Matrix Design Group, Inc.  
2425 Research Parkway, Suite 300  
Colorado Springs, CO 80920  
O 719.575.0100  
F 719.575.0208  
matrixdesigngroup.com

December 3, 2025

**RE: Rolling Meadows Parkway/Prairie Song Drive Roundabout Configurations and Traffic Operations**

**WESTBOUND
FASTEST PATH**

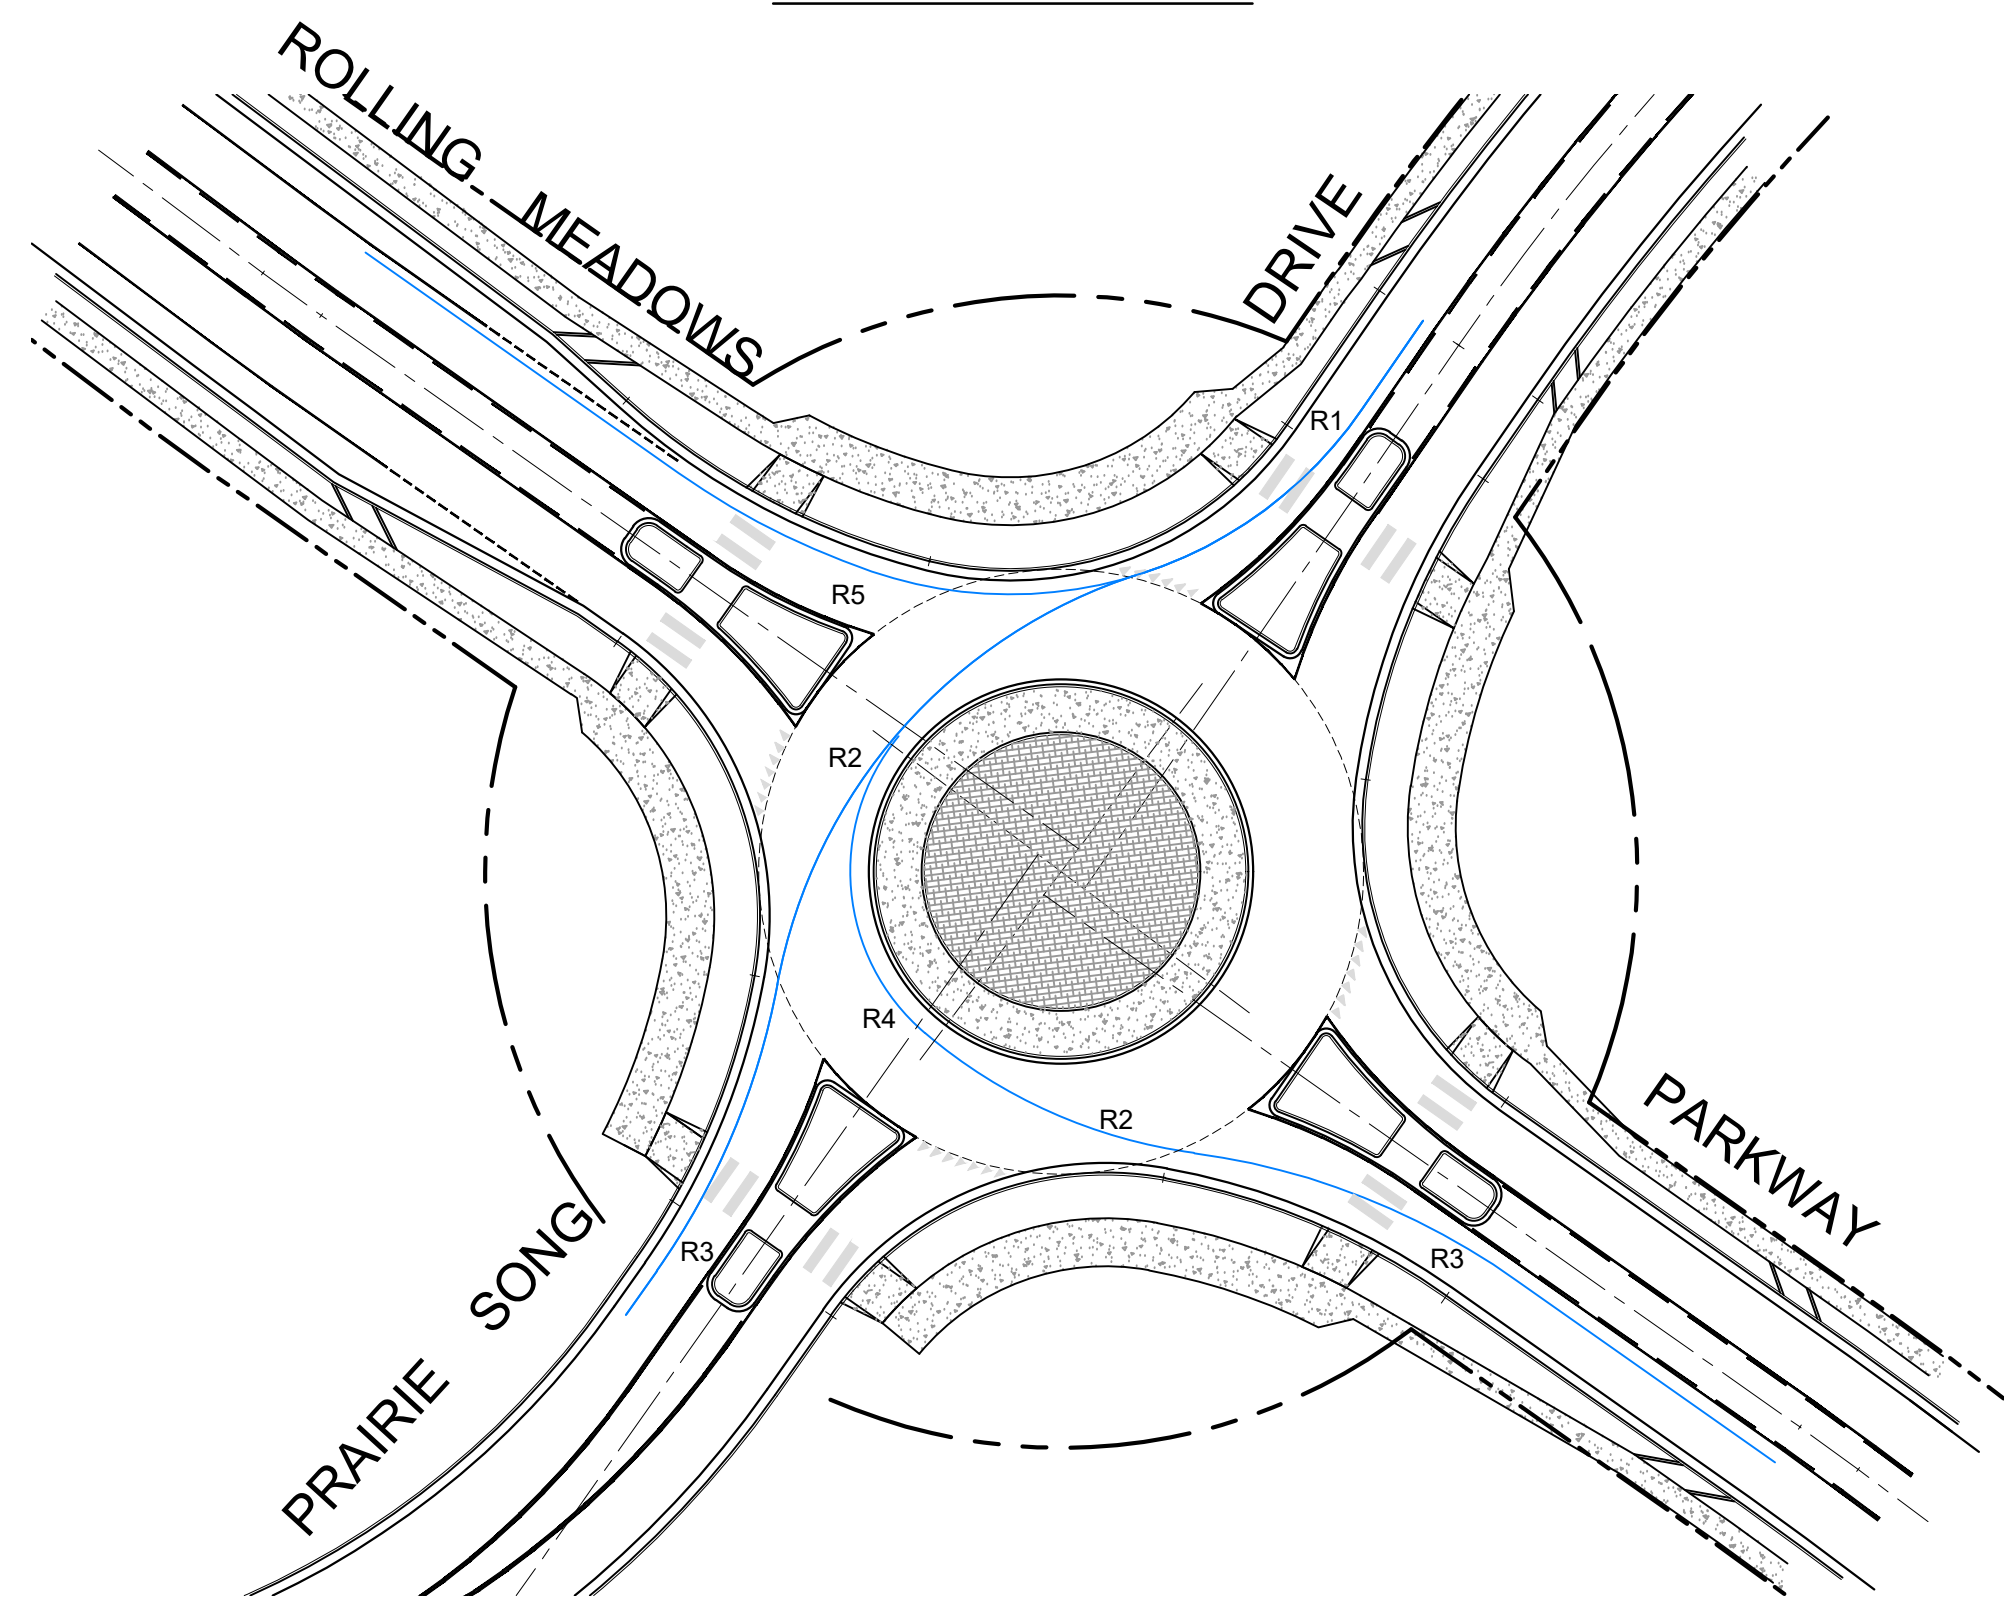
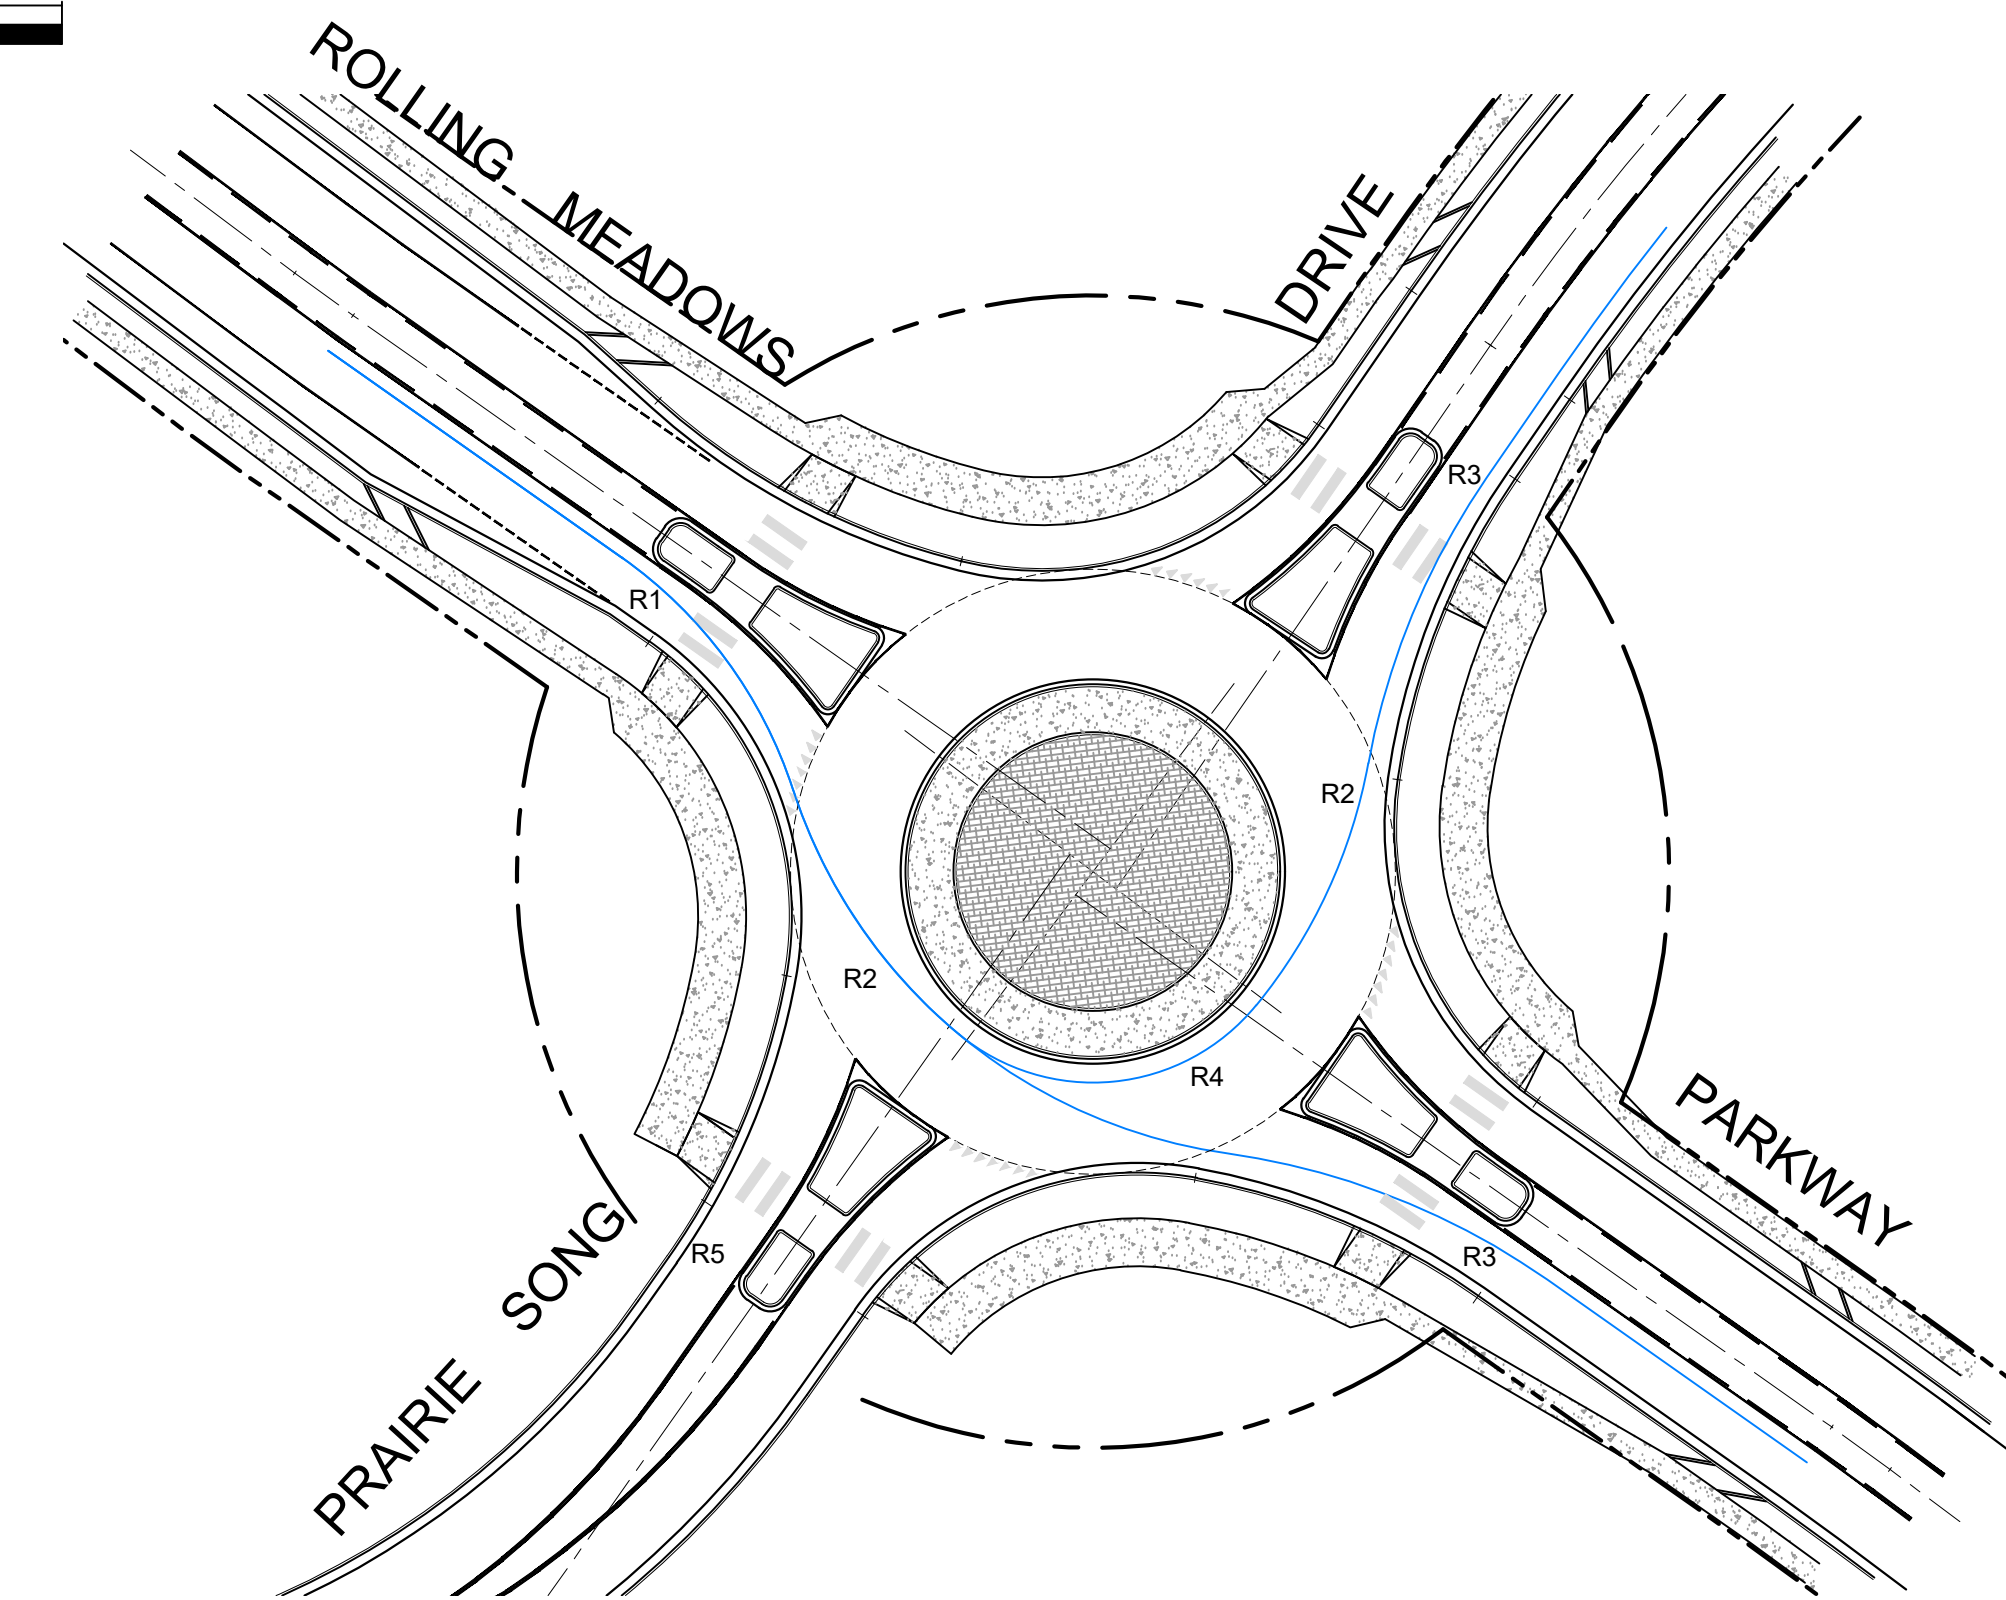
El Paso County now follows NCHRP 1043 for roundabout design and design checks (Appendix A-1 of the NCHRP document). Please ensure all design checks shown in the NCHRP document are met.

noted, NCHRP 1043 used for updates
